Upgrade of the Chester Hill Resource Recovery Facility (MP_0052)

Response to Submissions

Prepared for Builders Recycling Operations Pty Ltd

February 2019

Figure 3.1 - Ground Floor Plan

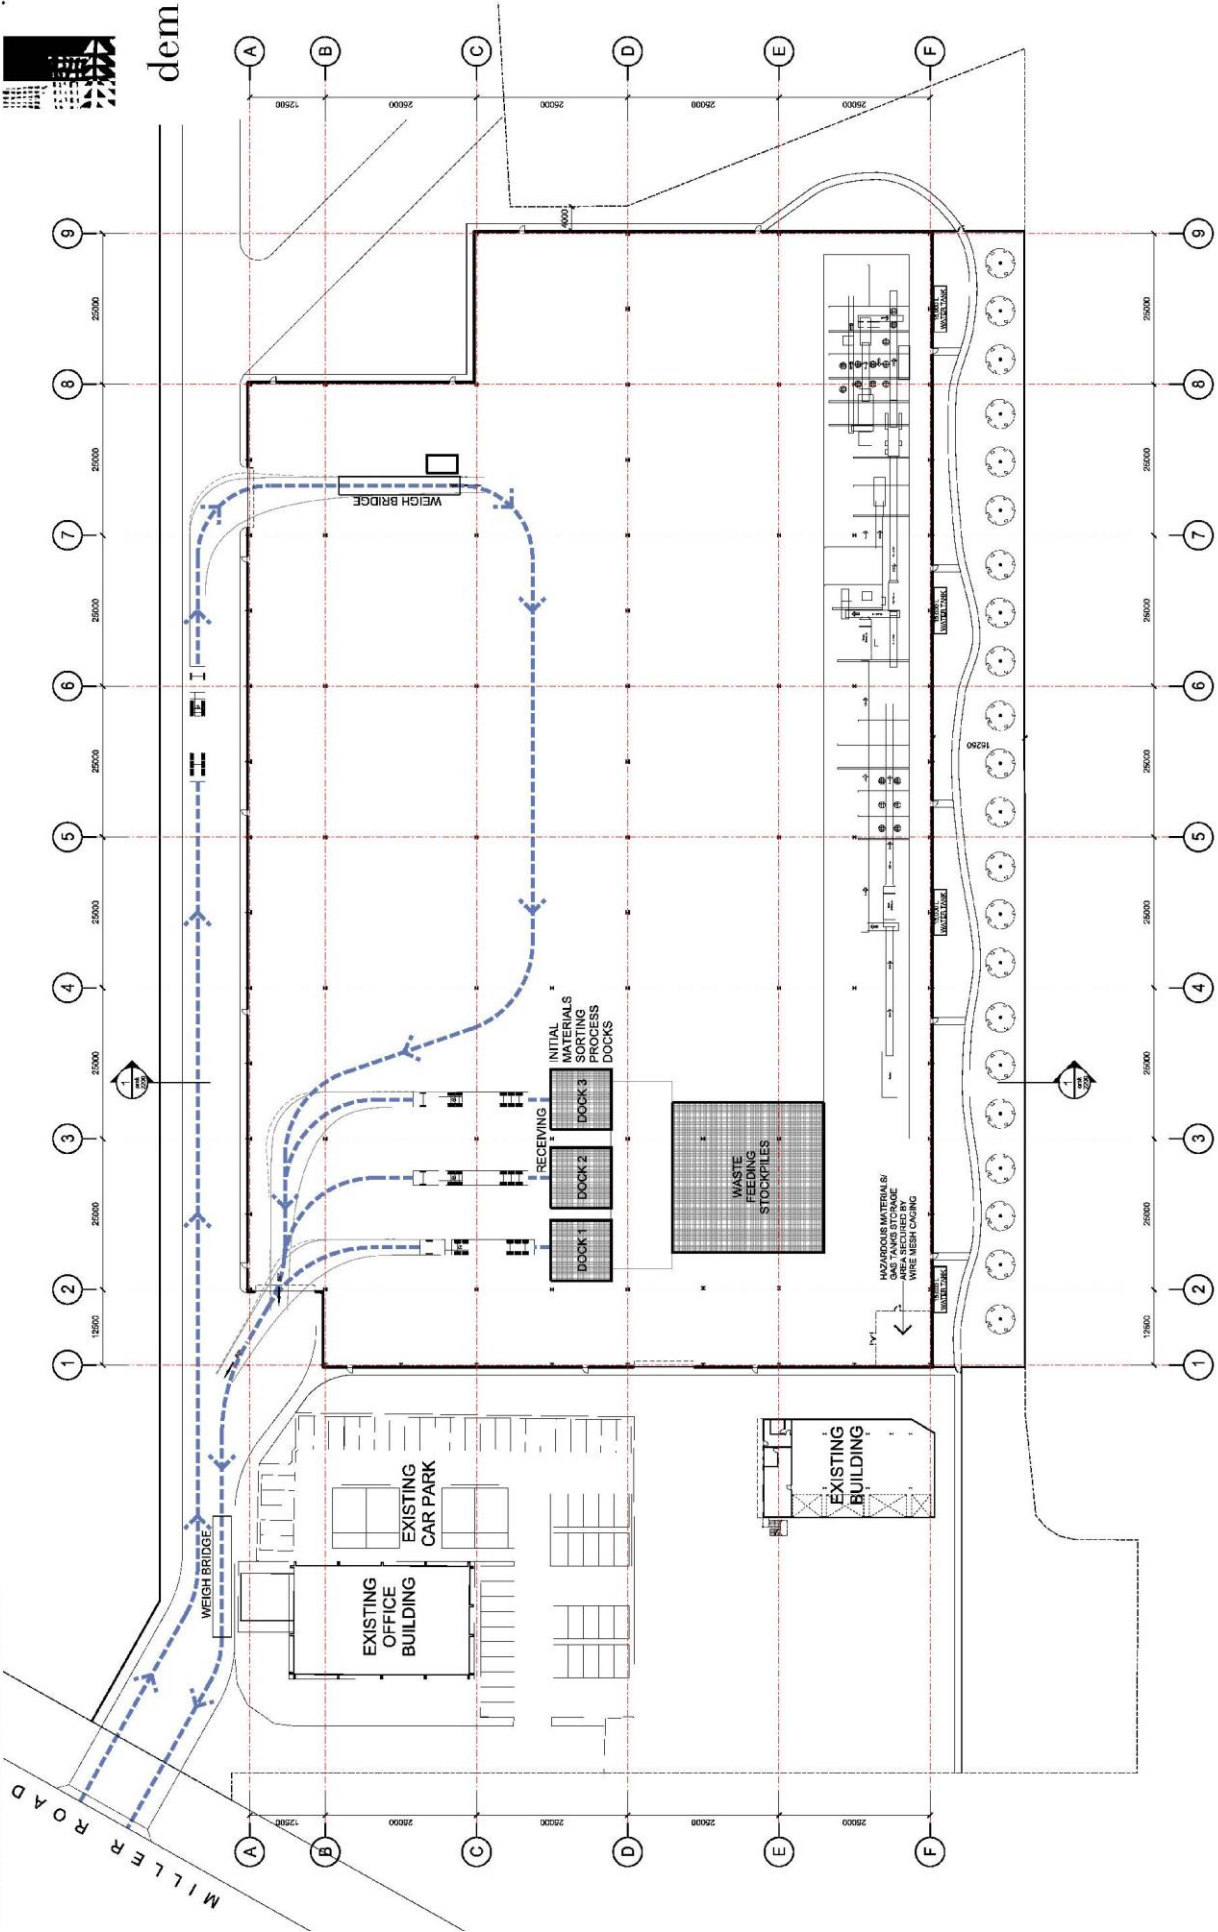
Aspect	Issue	Response	Reference
Site plan and cross sections	Need for EA to include appropriate architectural drawings that include a site plan, cross sections and elevations in correct detail	The relevant plans have been updated to include cross sections and elevations in appropriate detail. A new ground floor plan has also been provided showing internal truck flow paths.	Appendix A
	Need to identify use of land located behind staff parking	The land behind the staff car park does not form part of the major project approval or the modification application. While leased to BRO, it is currently being separately used for the retail of landscape supplies.	
Landscape plan	EA should incorporate a landscape plan that is consistent with desired character objectives for general industrial precincts	A landscape plan will be submitted for the approval of the Secretary prior to construction commencing. The landscape plan will take into consideration the final Fire Safety Study (FSS) in particular the need for perimeter access, as well as the principles identified in the DCP relevant	Included in revised mitigation measures in Section 6 of this report
